Application number: 2024/92103	
What is the application for?:	Erection of storage building and associated works
Address of the site or building:	Pennine Foods Ingredients Ltd, Crosland Road, Oakes, Huddersfield, HD3 3PA
Postcode:

User comments

DRAWING DESCRIPTION		
EXISTING & PROP ELEVATIONS		
JOB TITLE		
PENNINE FOODS, CROSLAND RD HUDDERSFIELD HD3 3PA		
CLIENT		
PENNINE FOODS		
DRAWN BY	SCALE 1:100 @ A1	
DATE	DRAWING NO.	REVISION
APRIL 2024	2042-00-02	-
CHECKED

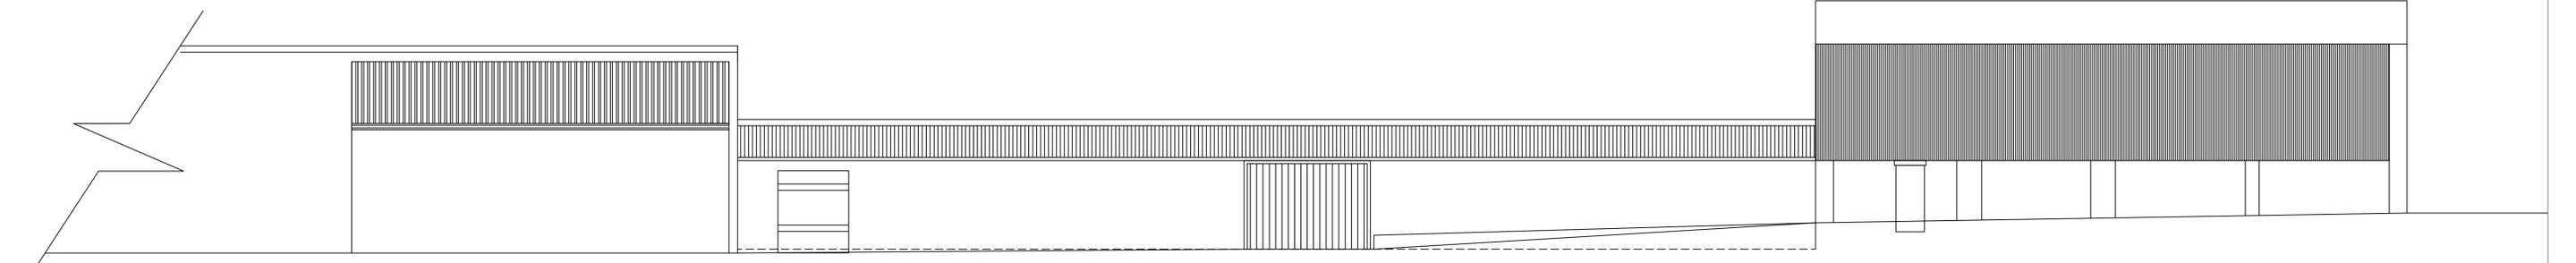
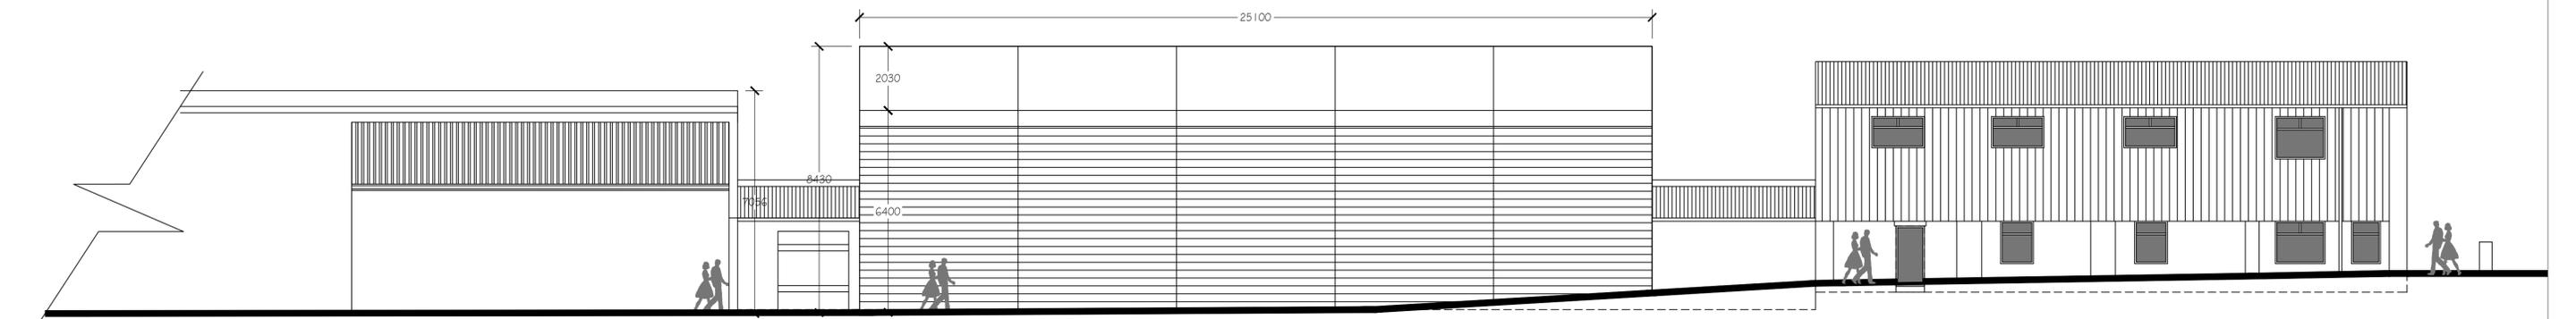
Type of comment: An objection	
Do you wish your comments to be published on the website anonymously?	No
<p>New structure is directly adjacent to my property, this would have an effect on my living conditions, looking at the plans the height of the building would compromise natural daylight. The trees overhanging my property (which Kirklees are responsible for) so having a building of that height I would no natural light at all, so having to have lights on in the house during the day impacting on my bills.</p> <p>Height of building will take away the view we have from the upstairs window looking out across the valley.</p> <p>Noise- Having a building so close to my property, when operating machinery would be a noise disturbance all day from 7.30-4.30.</p> <p>Application says temporary building - how long will it be there for?</p> <p>Will the working hours remain the same or are they planning to extend because of the new building.</p> <p>Building so close to property possibly could attract vermin if it's used for storage.</p> <p>Approving the application would possibly have an affect on the value of my property.</p>
